# **Consultee Comments for Planning Application 2021/1338/FUL**

Application Number: 2021/1338/FUL

Proposal: Creation of 2 no. ponds which will be 300m<sup>2</sup> each and with different depths to a maximum of 2.5 meters.

On Behalf Of: Public Rights Of Way Officer

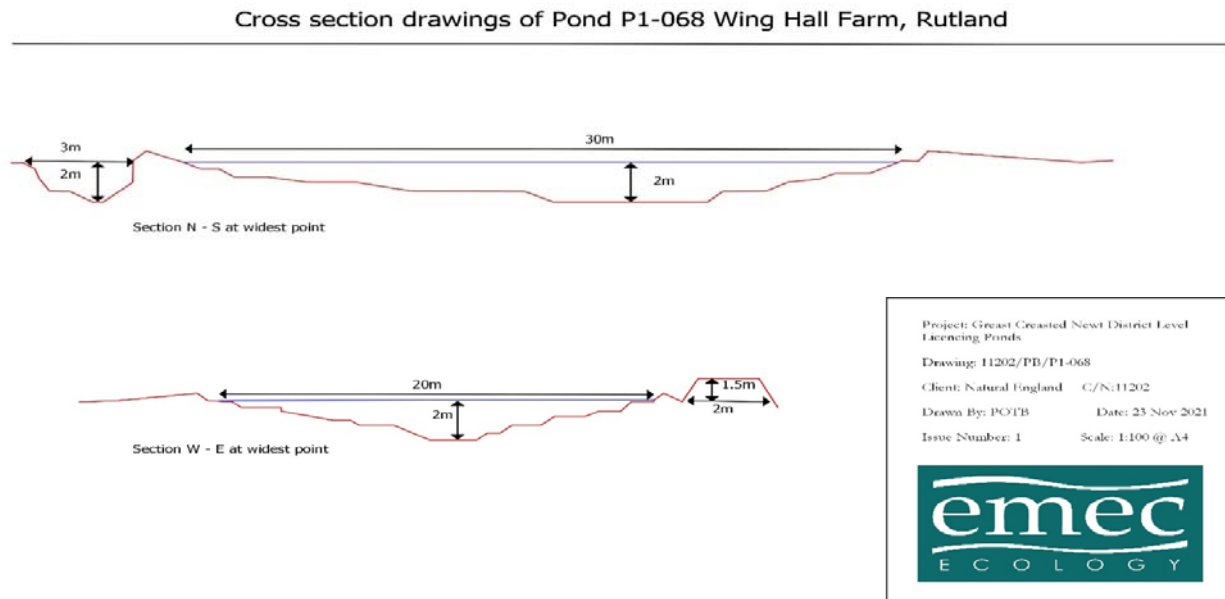
Objection.

Based on information provided the ponds appear to obstruct the definitive line of footpath E261. The applicant has stated that no rights of way will be affected (no diversions required etc.). There is insufficient detail in the plans provided to have any confidence in this statement. Applicant needs to provide further detail to support this position.
